Subject: BR/99/20/PL

Please see comments of our EH HMO Officer. These are mostly for information but I don't know whether you need to amend the plans re having an escape window for unit 3?

PROPOSED GROUND FLOOR PLAN

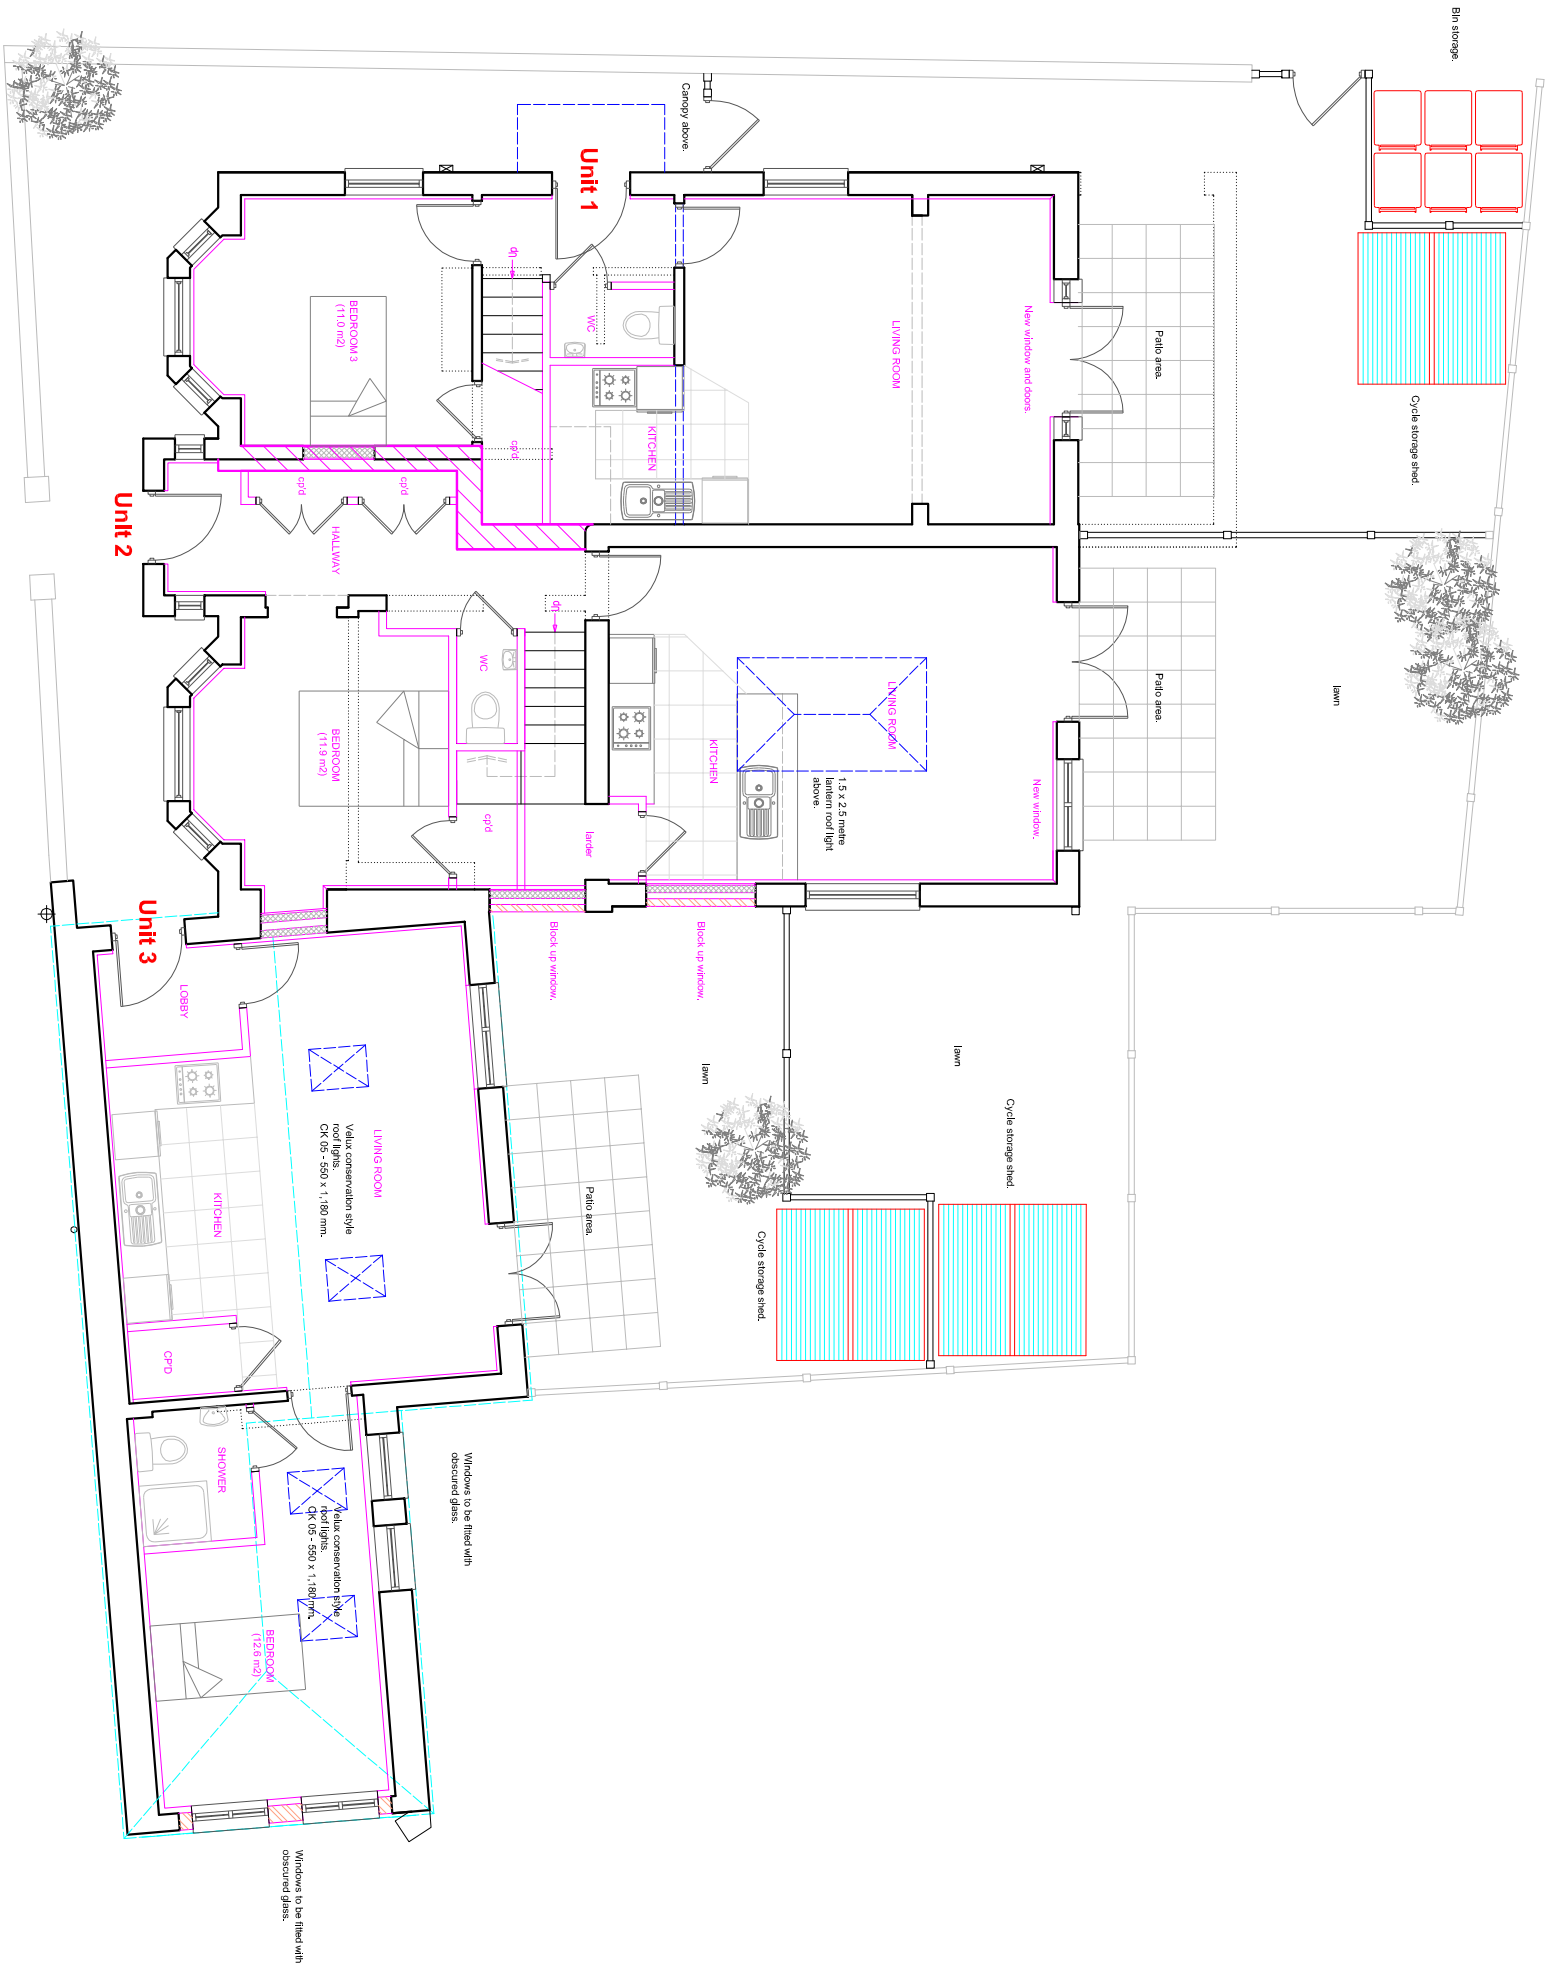
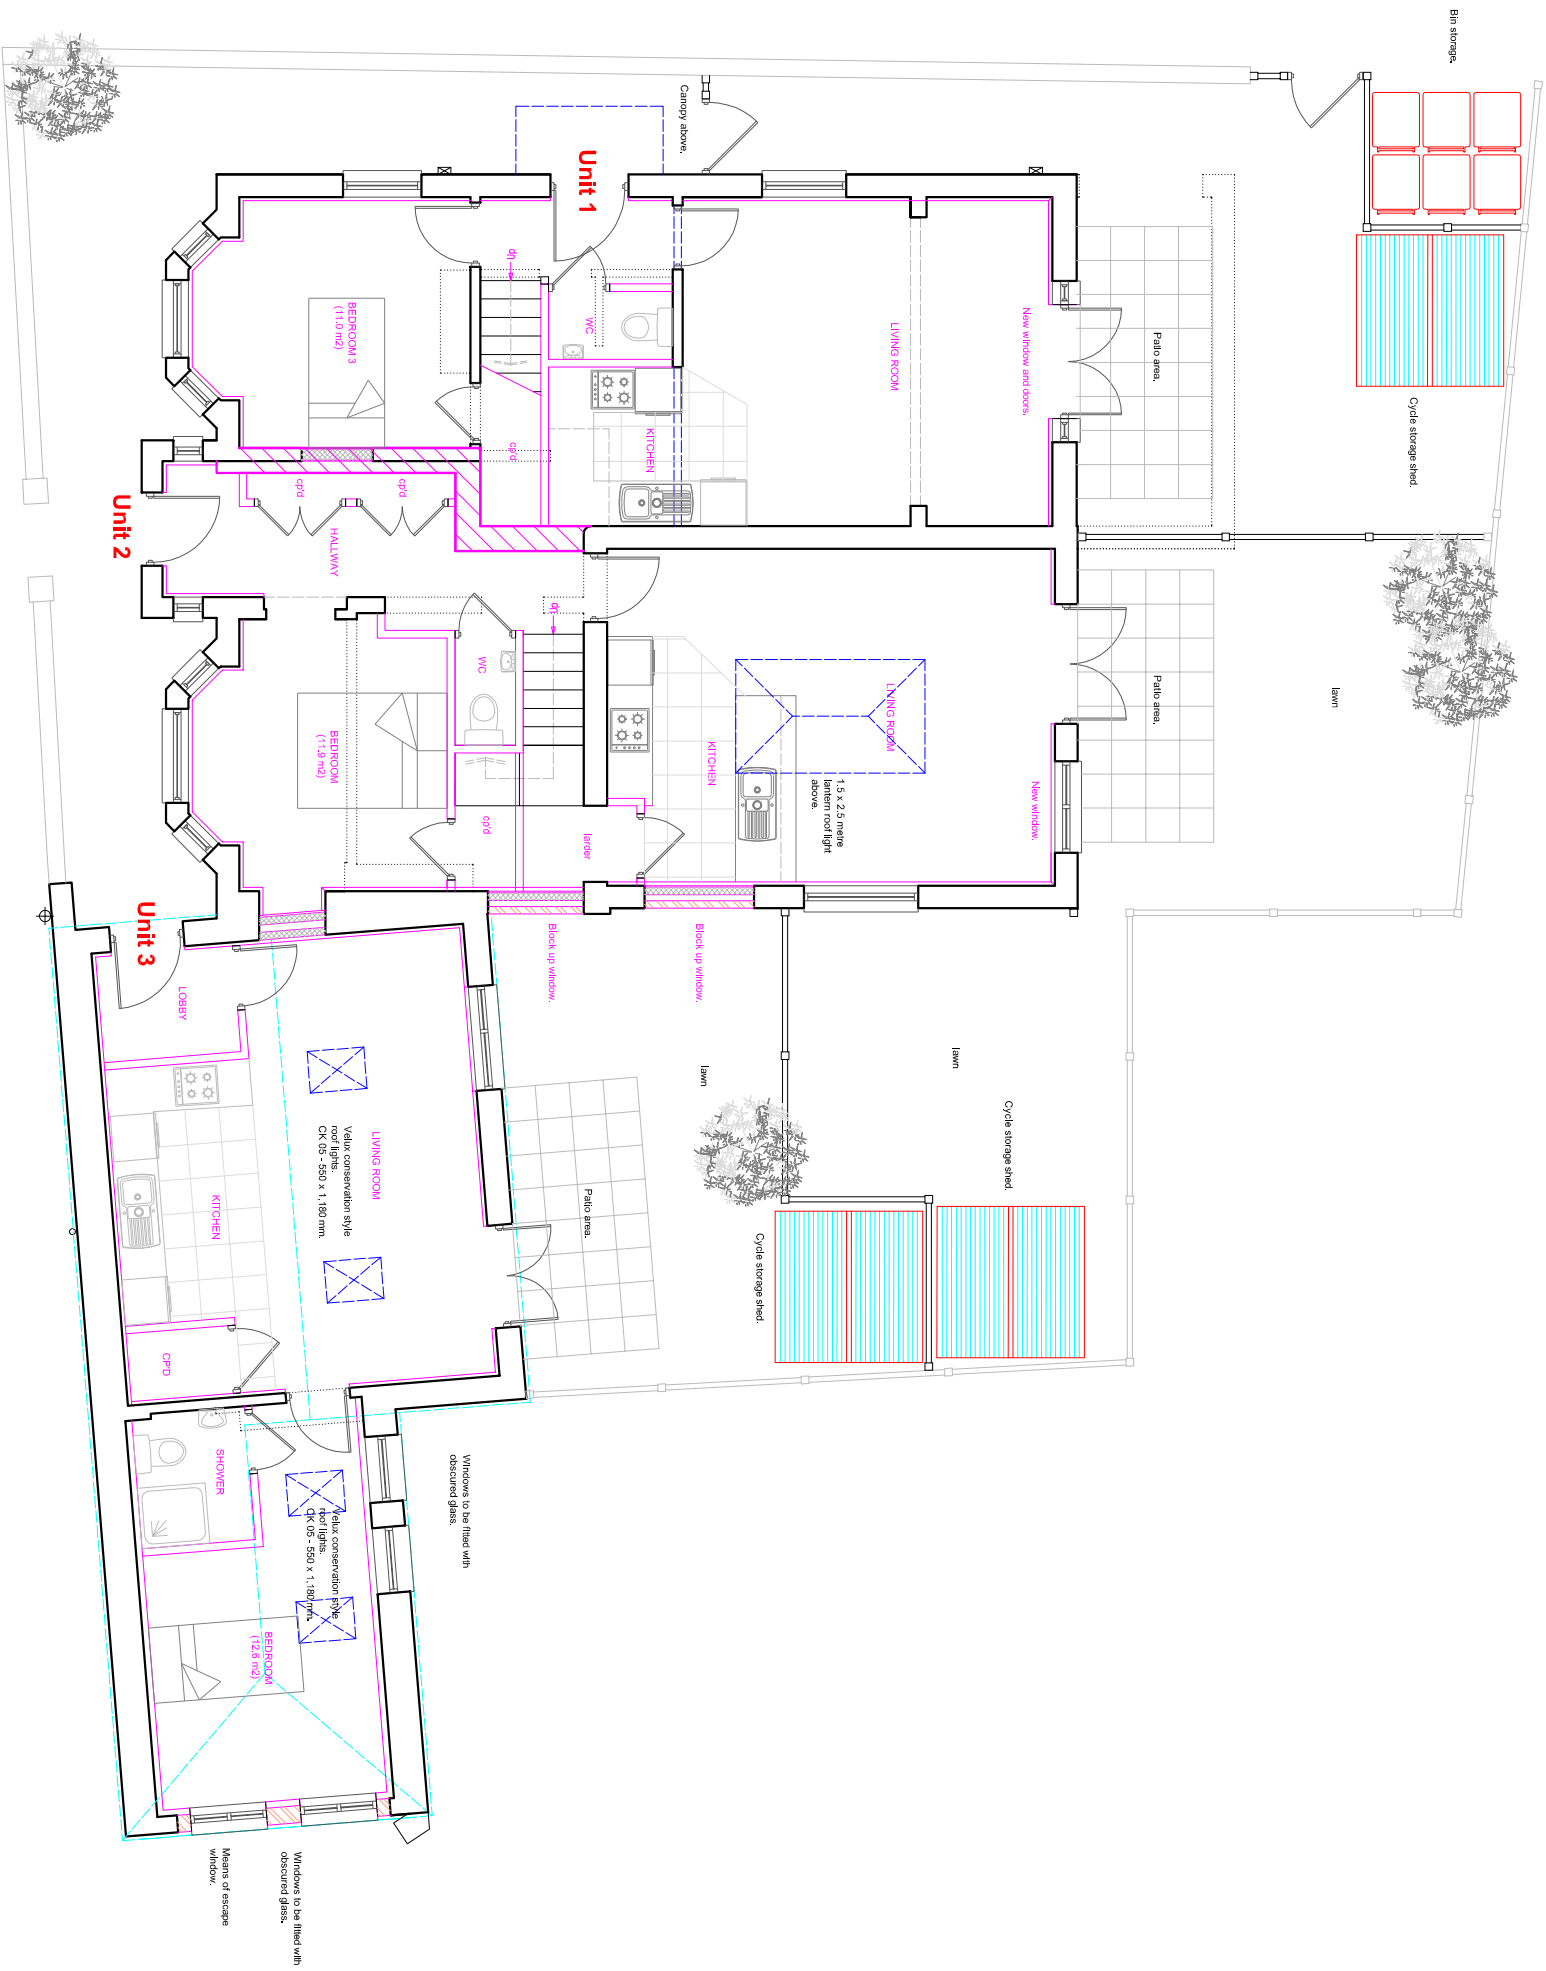
"An escape window with a sill height of not more than 1100mm from finished floor level, with an unobstructed openable area of 0.33m² and have a minimum 450mm height and 450mm width must be provided in the bedroom of unit 3."
